WEST SUSSEX COUNTY COUNCIL CONSULTATION

TO:	Arun District Council FAO: Amber Willard
FROM:	WSCC - Highways Authority
DATE:	24 February 2022
LOCATION:	The Pagham Club 2 West Front Road Bognor Regis PO21 4SY
SUBJECT:	P/2/22/DOC Approval of details reserved by condition imposed under P/10/20/PL relating to conditions 3-internal noise levels, 6-covered & secure cycle parking; 7-electric vehicle charging & 8-storage of waste.
DATE OF SITE VISIT:	n/a
RECOMMENDATION:	Advice
S106 CONTRIBUTION TOTAL:	n/a

Block Plan REV02

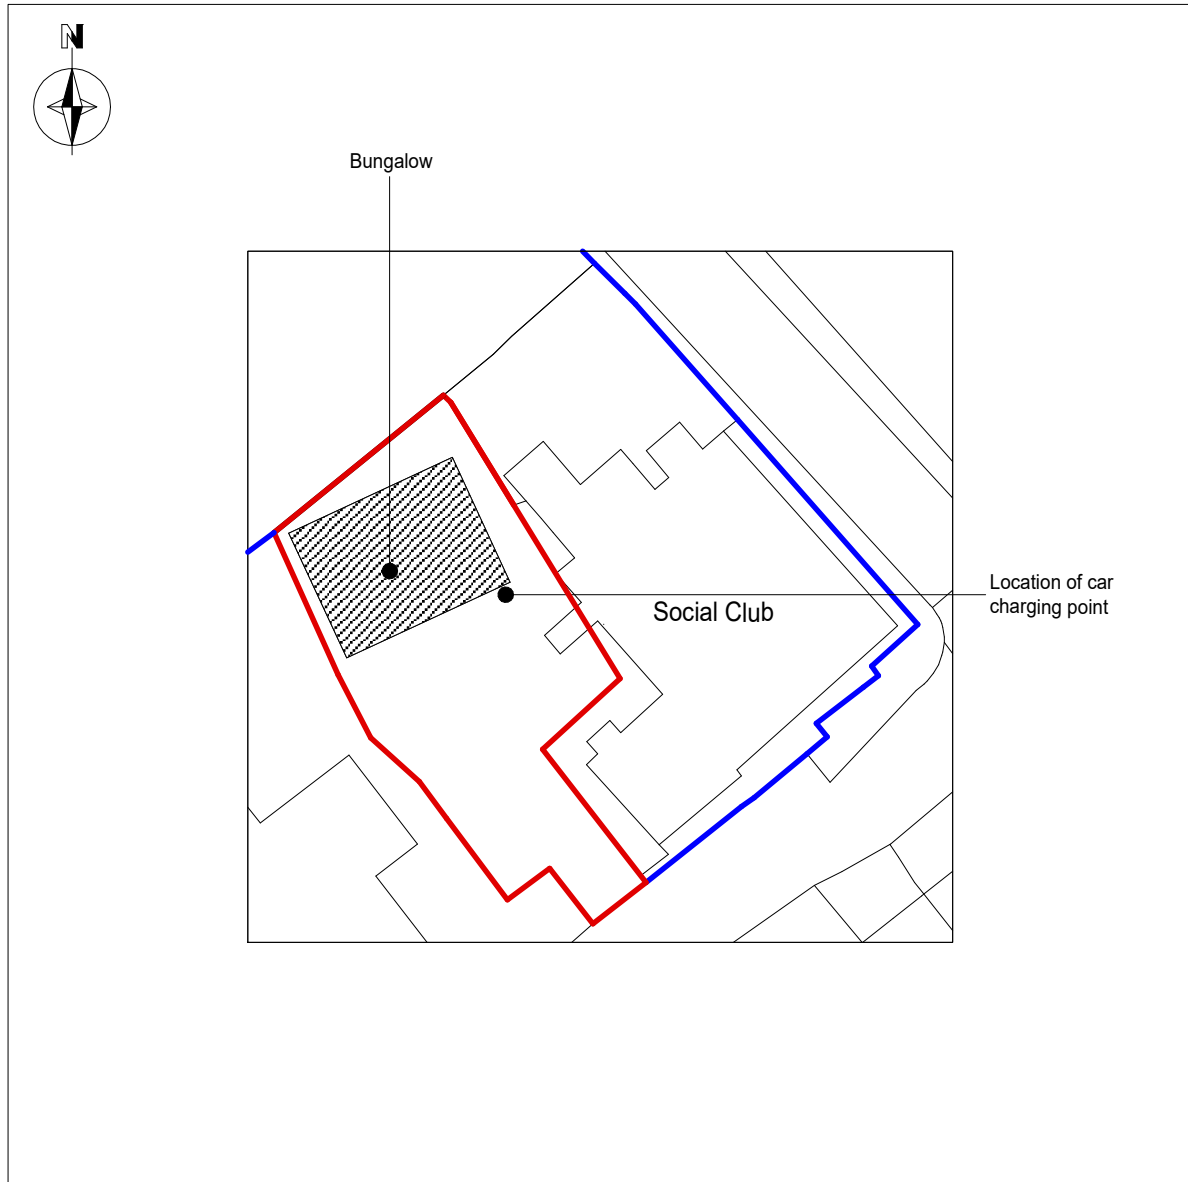
The proposed plan demonstrates the location of the EV charging facility and the provided photo demonstrates that the EV facility has been installed. As such, the LHA are satisfied that this condition can be discharged.

As above, the LHA are satisfied that Condition 7 can be discharged.
